# BENT GRASS EAST COMMERCIAL FILING 3

## EL PASO COUNTY, COLORADO PRELIMINARY PLAN

#### COVER SHEET

ADJACENT PROPERTY  
OWNERS AND TRACT  
MAP

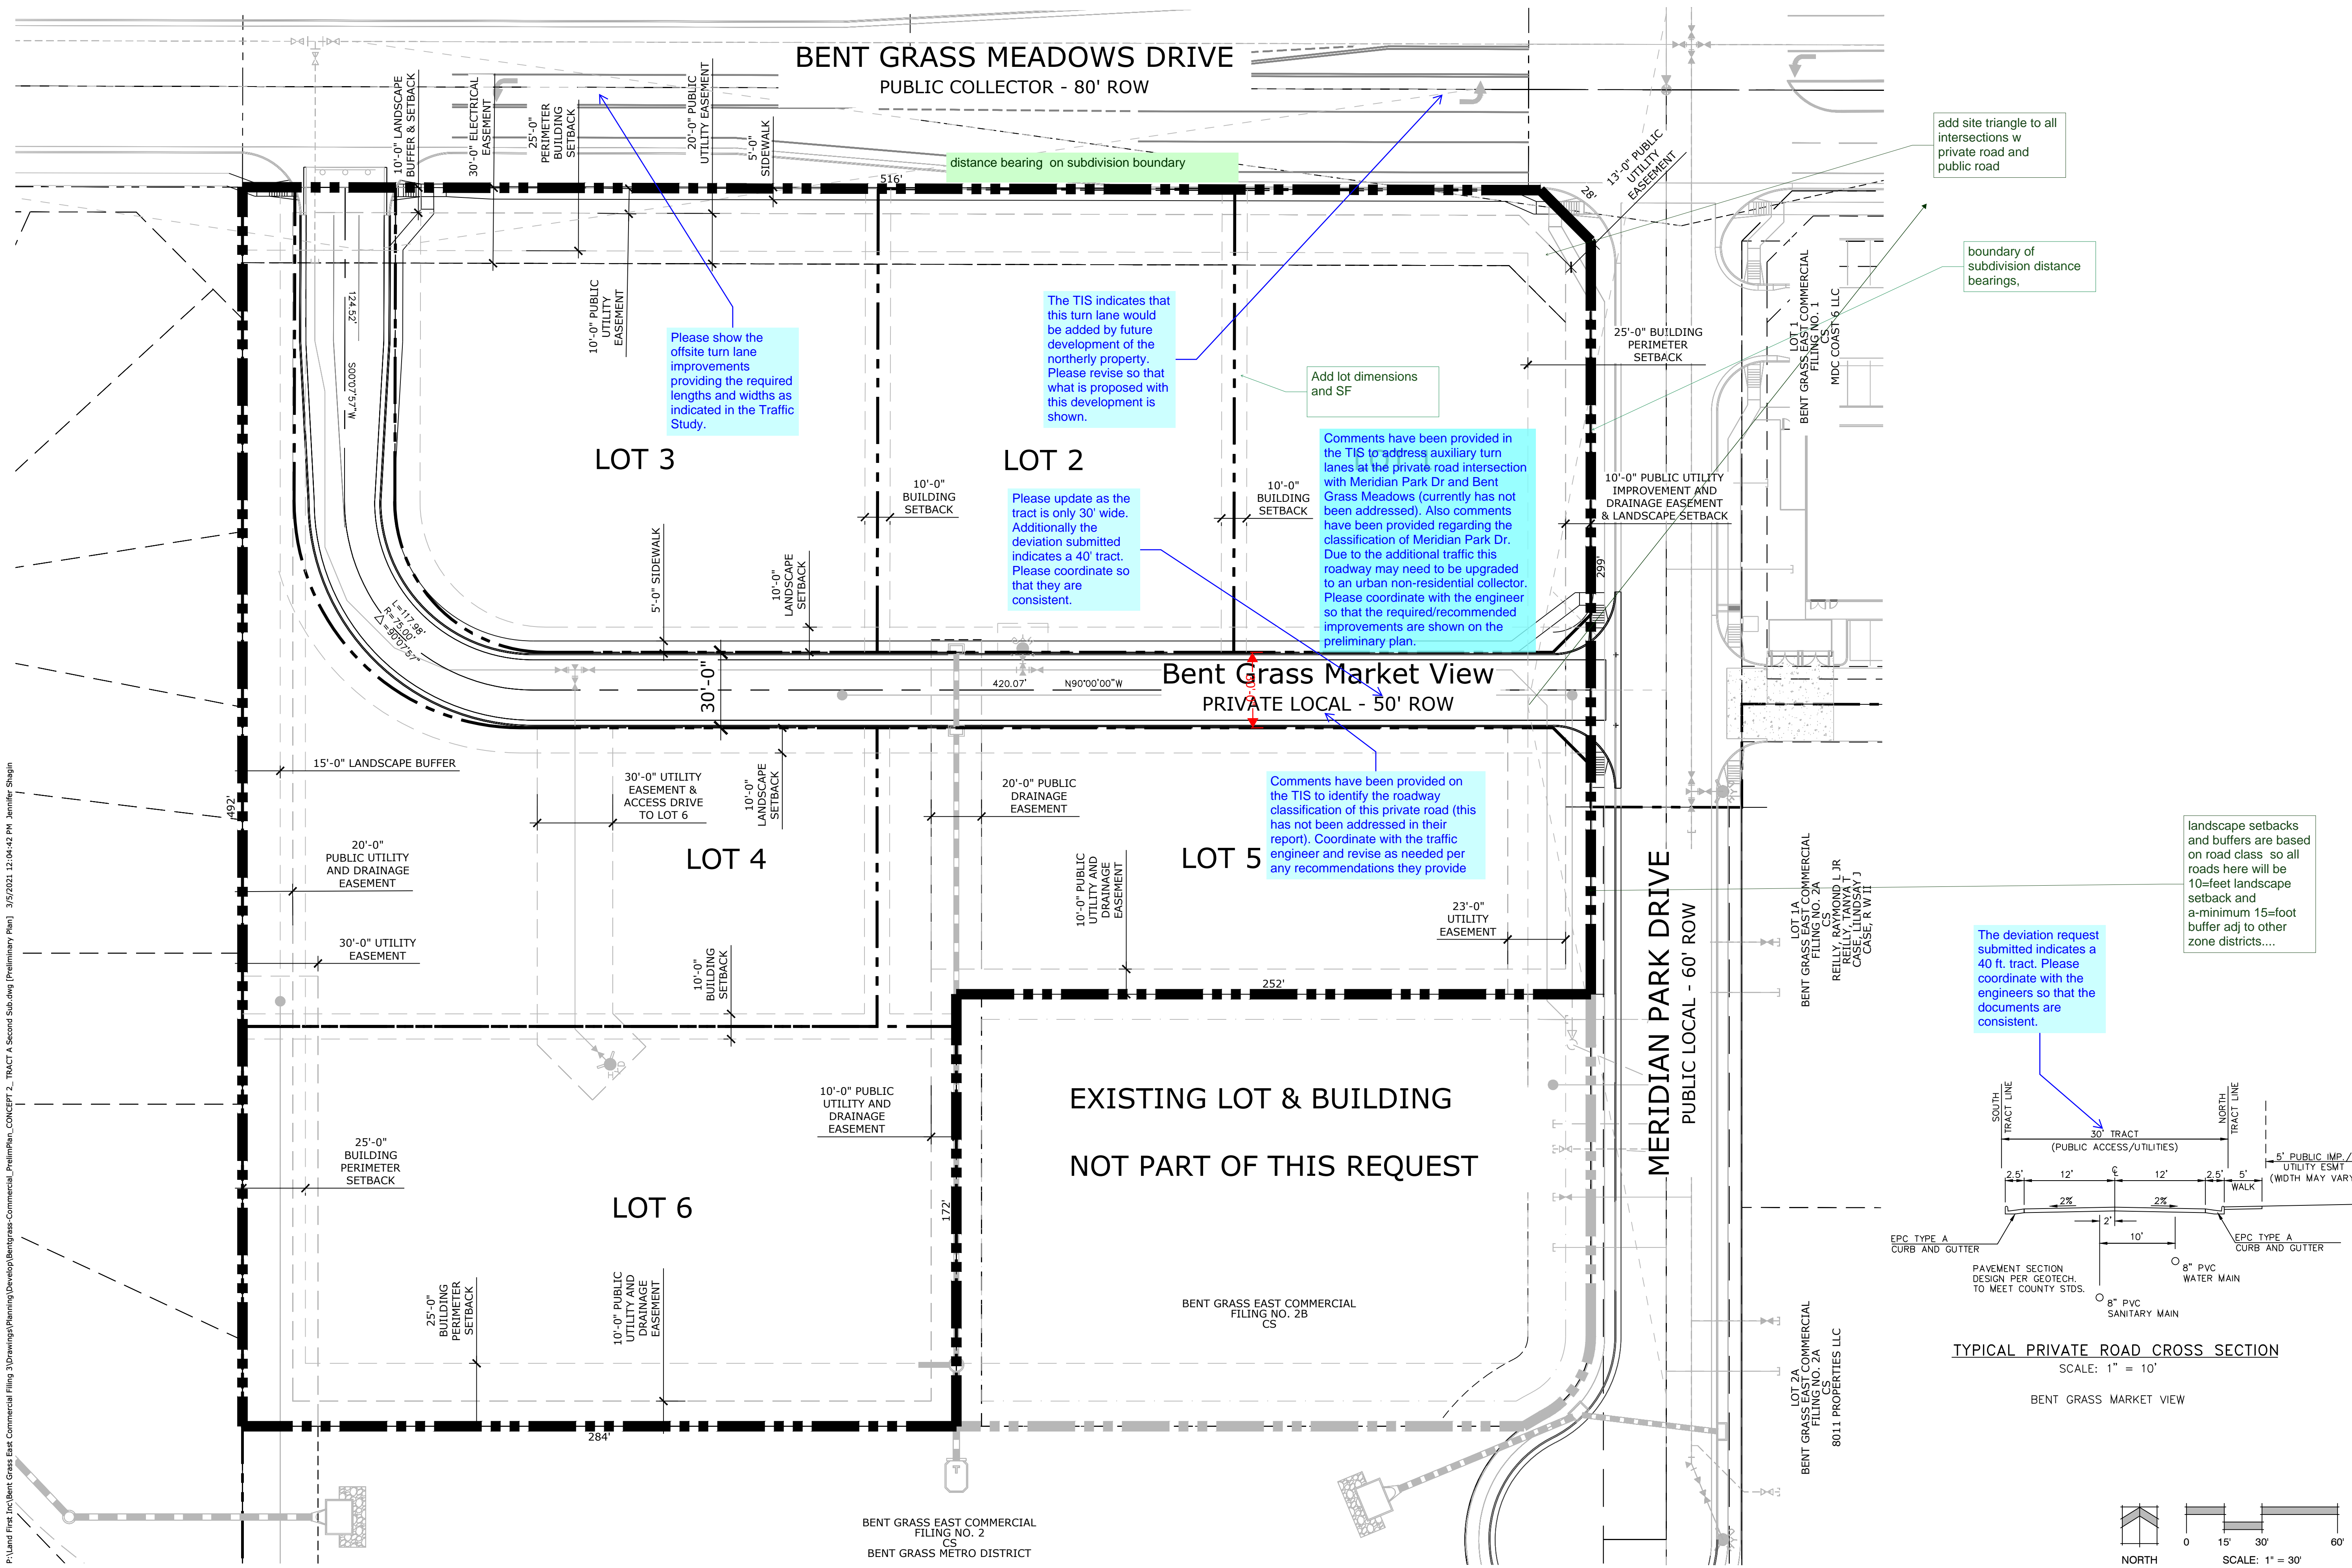
private road, utility  
and drainage

Updated to reflect private road,  
utility and drainage use

Updated to Bent  
Grass Market View

PRELIMINARY GRADING PLAN

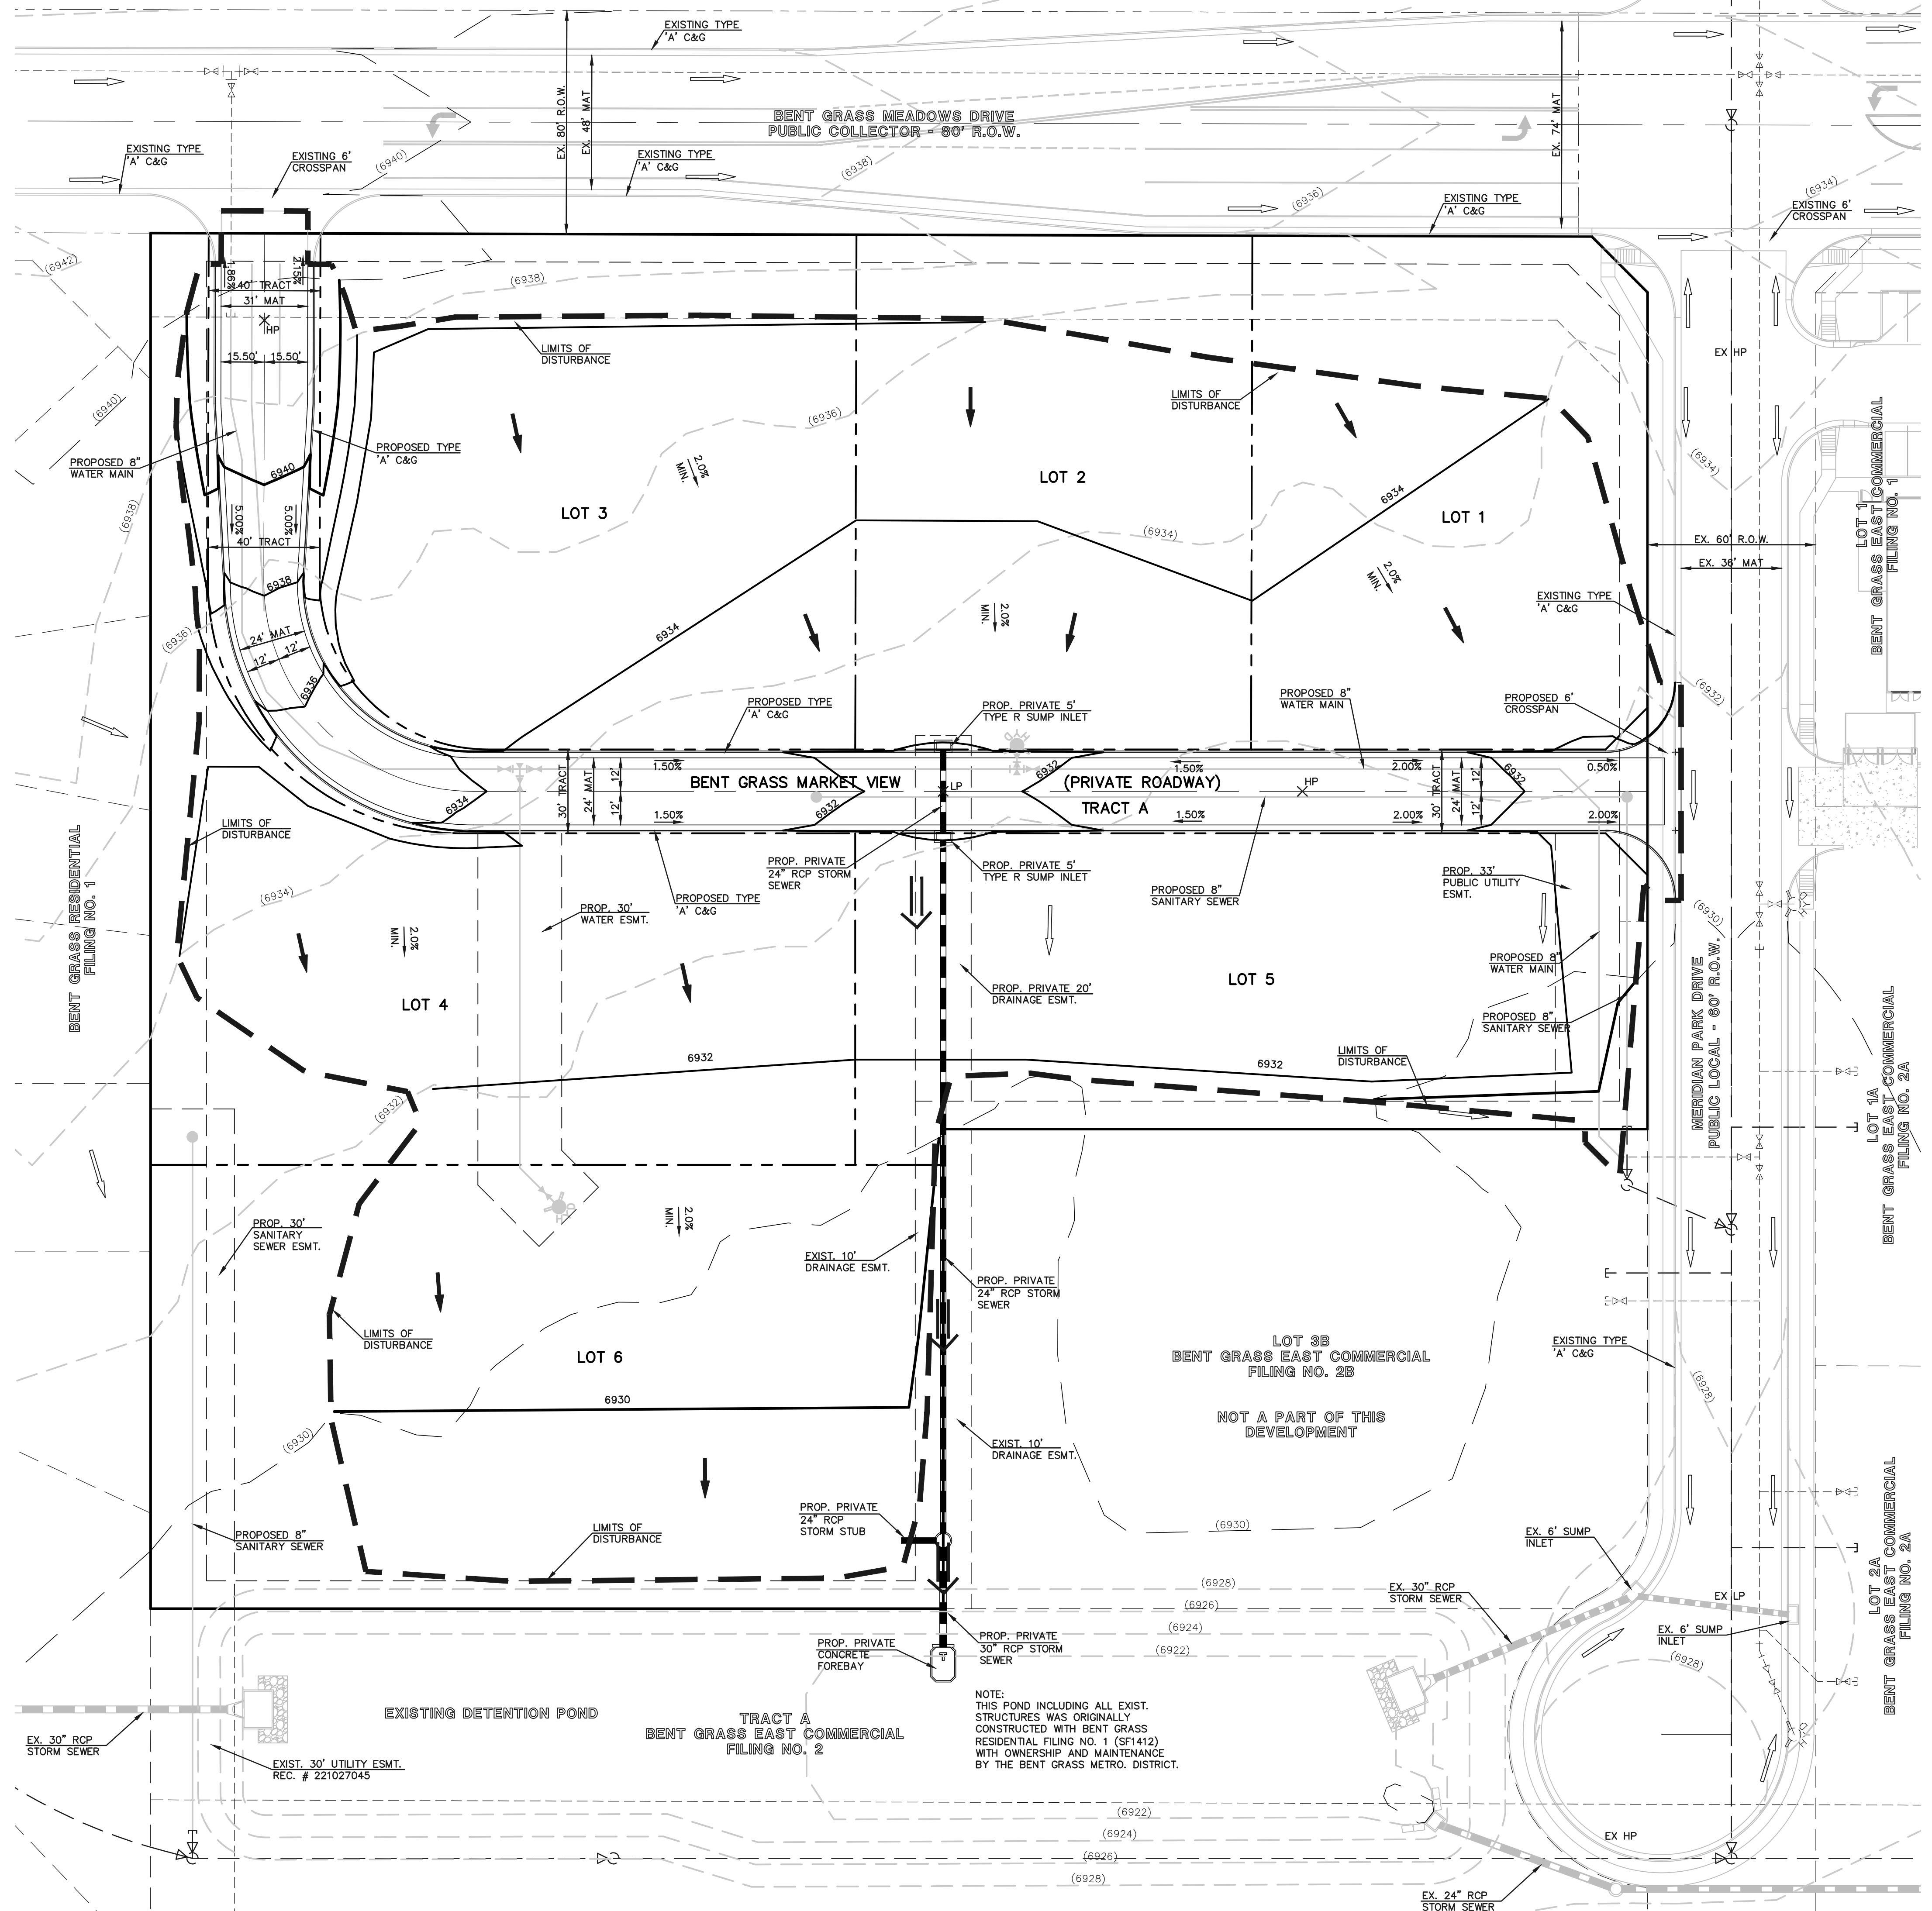
Please label the proposed storm sewers as private

Make a note that this pond (and the existing inlet and outlet structures) was originally constructed with Bent Grass Residential Filing No. 1 (SF1412).

Added
